# CITY OF ALBUQUERQUE

March 13, 2019

**Re: Juan Tabo Hills Estates (Volterra)- Pulte Homes  
Erosion and Sediment Control Plan  
Engineer's Stamp Date –no stamp- (M21E018\_P)**

Curb Storm Inlet Protection with Wattles

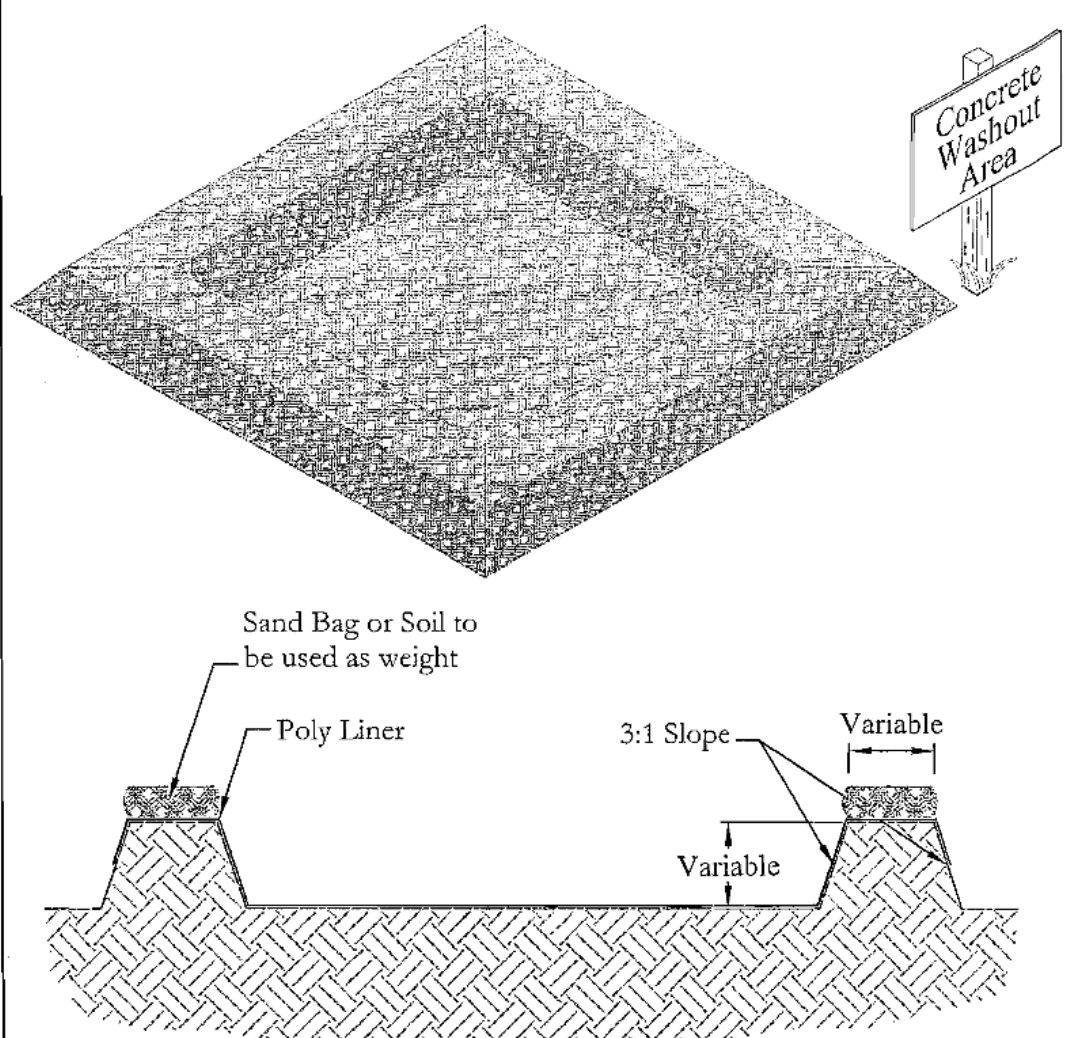
4. The cutback is too small and the wrong shape in the Cut-back curb detail. The cutback should resemble a V-ditch with the low-point away from the curb. A detail developed with home builders accompanies this letter.

BMP MAP LEGEND

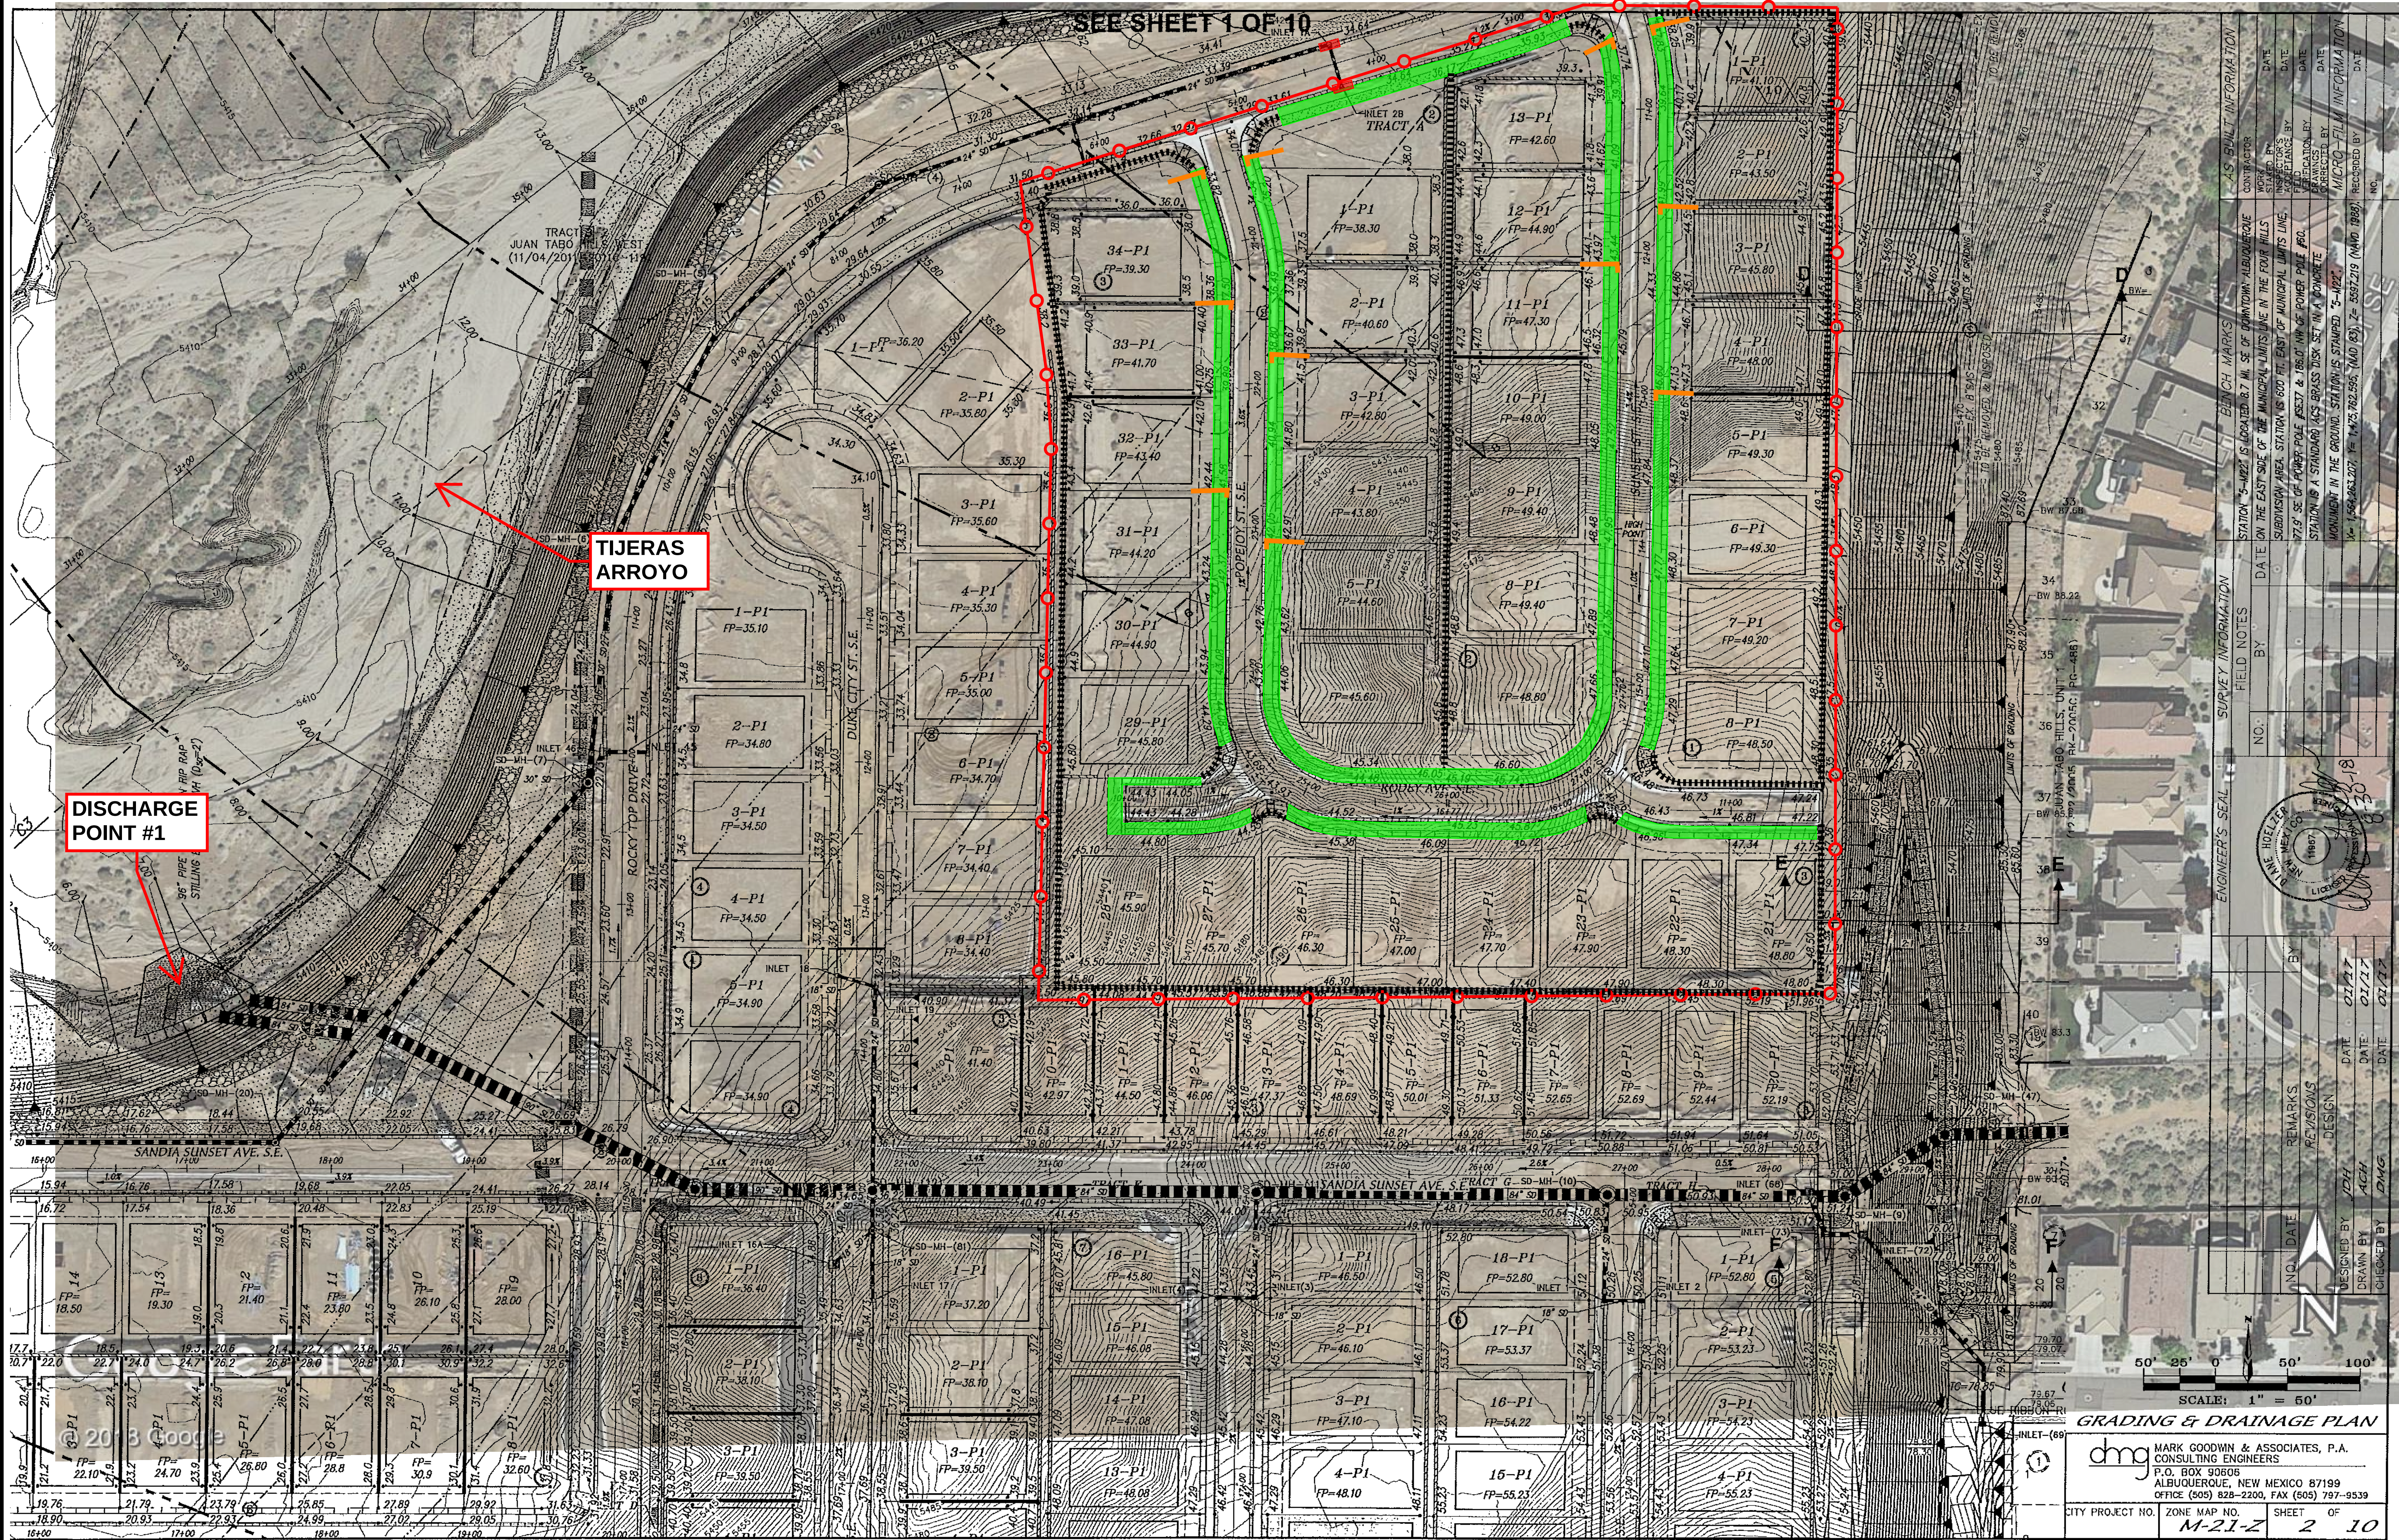
1. The plan is not sealed by a Registered Engineer in New Mexico or a Certified Professional in Erosion and Sediment Control. I reviewed the "In-training Certification" on Envirocert's website and a CPESC- In Training does not meet the standards in the Drainage Ordinance.

2. The site is too small on the sheet and the street names/lot numbers are not readable. Per the DPM, the minimum font size is 0.1 inches.

3. A filter sock, wattles or J-Hook silt fence at regular intervals is required in the cutback area on streets with a longitudinal slope steeper than 2.5% to help prevent erosion. Streets identified meeting this condition are: Harrier Hawk-4%, Rock Squirrel 3.4% and Sandia Sunset 2.6%, 3.15% and 3.7% (different reaches) . Slopes were obtained from the Work Order construction plans.
